Development Consent Order to Highways England project TR0 10022 Anne Morgan [REDACTED]  
 To the Examiner Stuart Cowperthwaite  
 Friends of Markeaton Park Responses to the Responses to 5th May 2020 Questions.

FIGURE 2.12D ENVIRONMENTAL MASTERPLAN (MARKEATON JUNCTION)

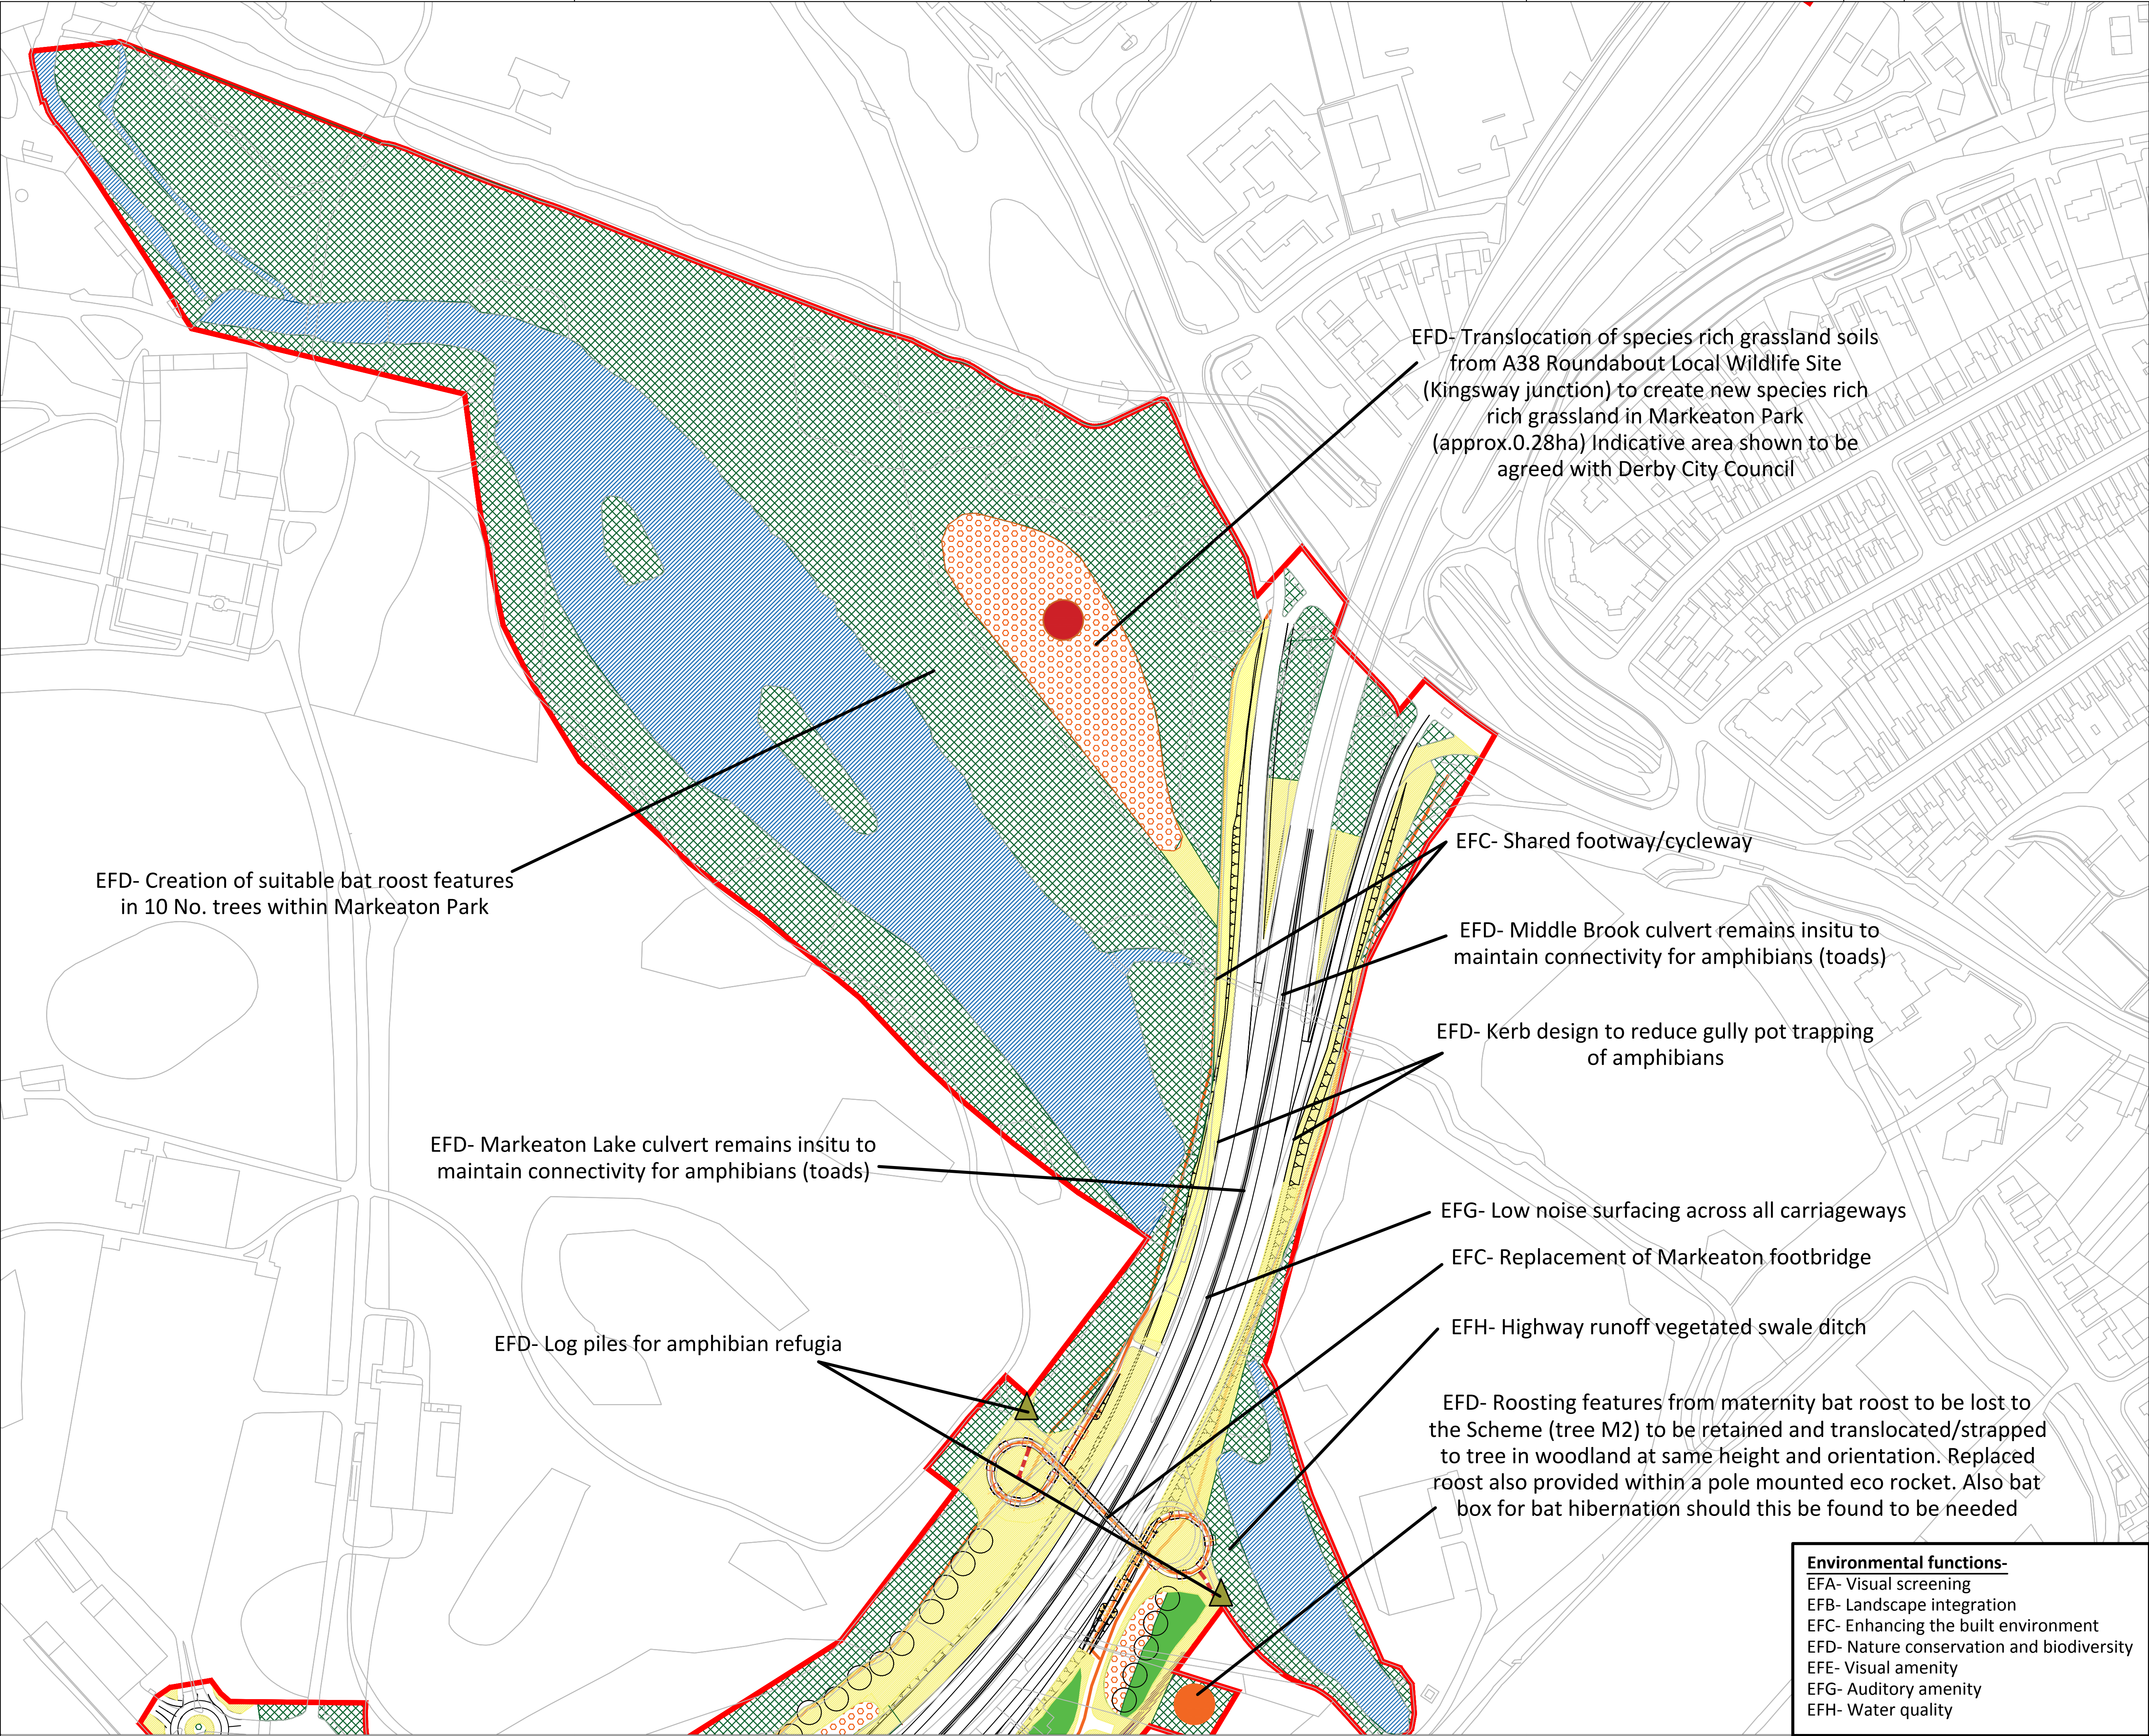
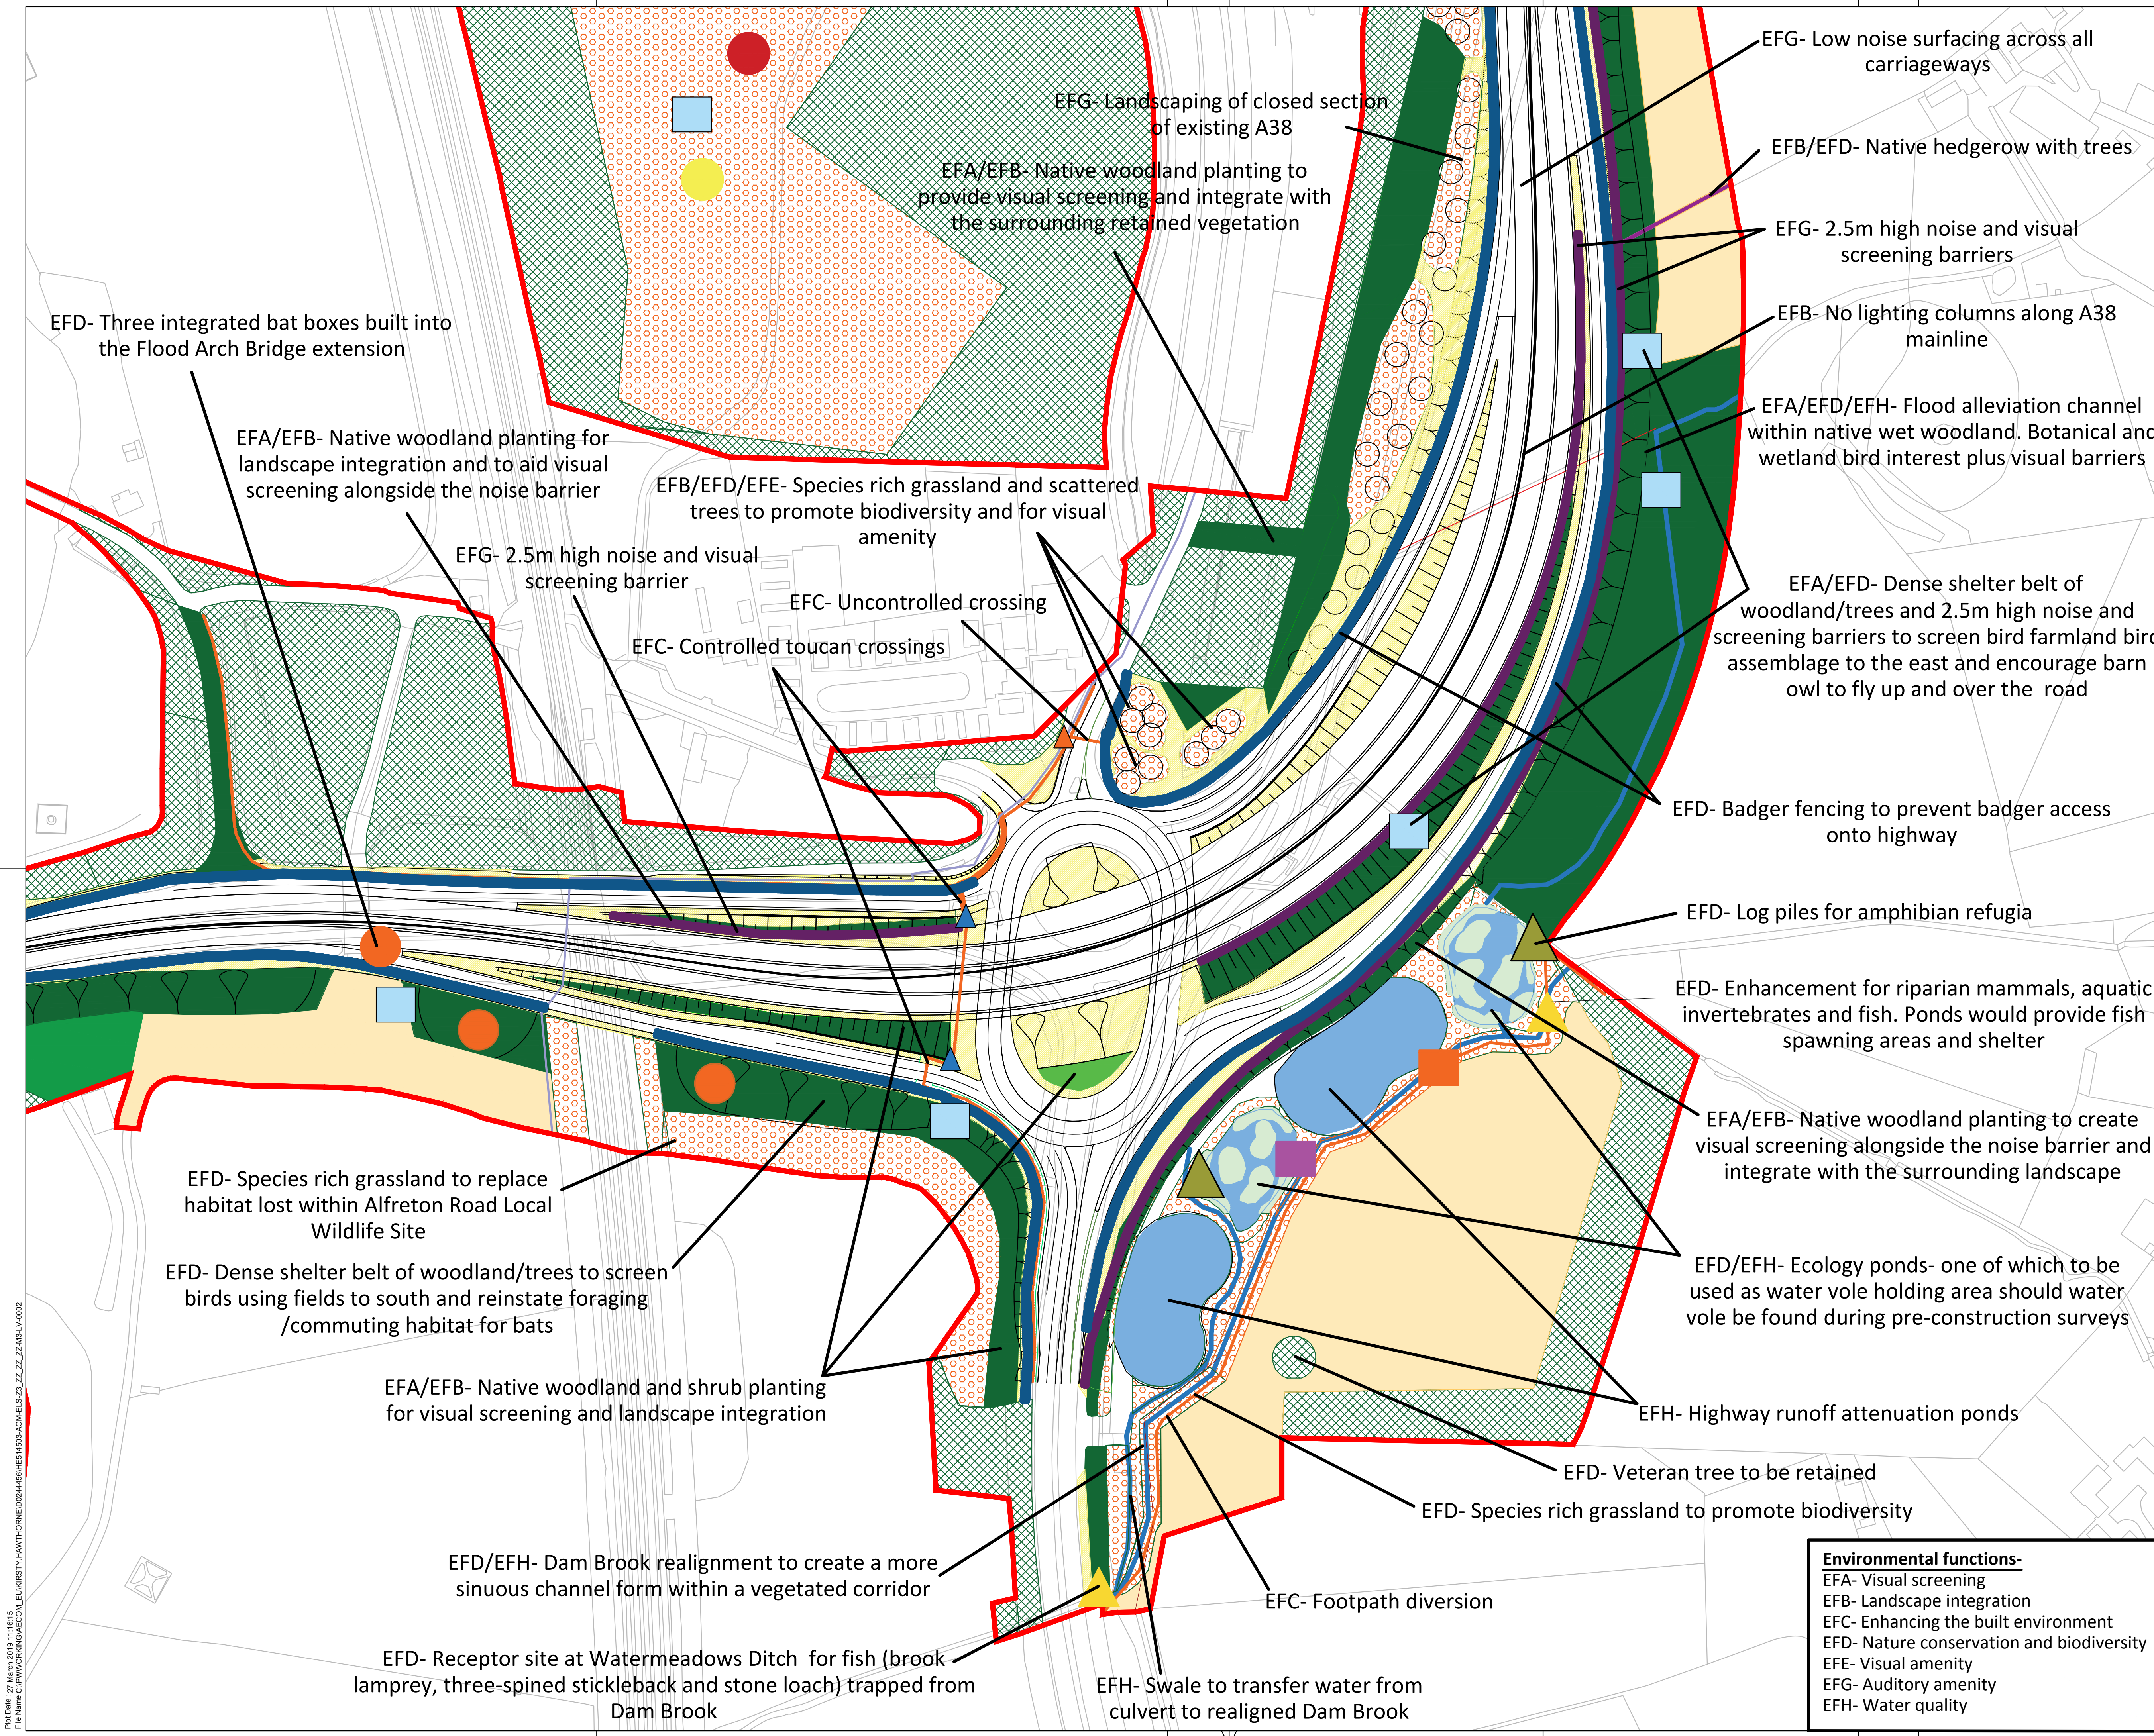
In response to the Examiner's question about trees Highways England directed us to ES Chapter 7: Landscape and Visual [APP045]. Studying those maps it was a shock to discover that there are NO plans to replace trees in mitigation for the loss of the present tree belt along Queensway. That is to be replaced by amenity grassland. Environmental Plans 6.2 Figures 7.8 A-C has twelve lists of plants. The numbers of trees to be planted (in linear strips at the edge of the slip roads or in triangles between the slip roads) is listed as a different percentage of each tree in each different list. The actual number will be determined at the Detail Design Stage. Presumably that is when the width of the Utility Diversion will be decided, and the numbers of trees that will be lost to pumps, drains and sewers etc. will become known. No ratio of numbers lost to numbers replaced is suggested, either for mitigation or for the Climate Change Law Obligations. The rules as to replacement if a plant dies within five years are clear. IT MUST be replaced. Will "vegetation to be retained" that dies within five years of having diggers going to and fro over its roots during construction, and subsequent utility repair work, also be protected by "MUST be replaced" rules? If so how many saplings for each 40 year old tree? What if the new path built with Heritage Funds is damaged every time a Utility has to be repaired? Tree DWT 26 is an irreplaceable Oak old enough to shed a branch naturally.
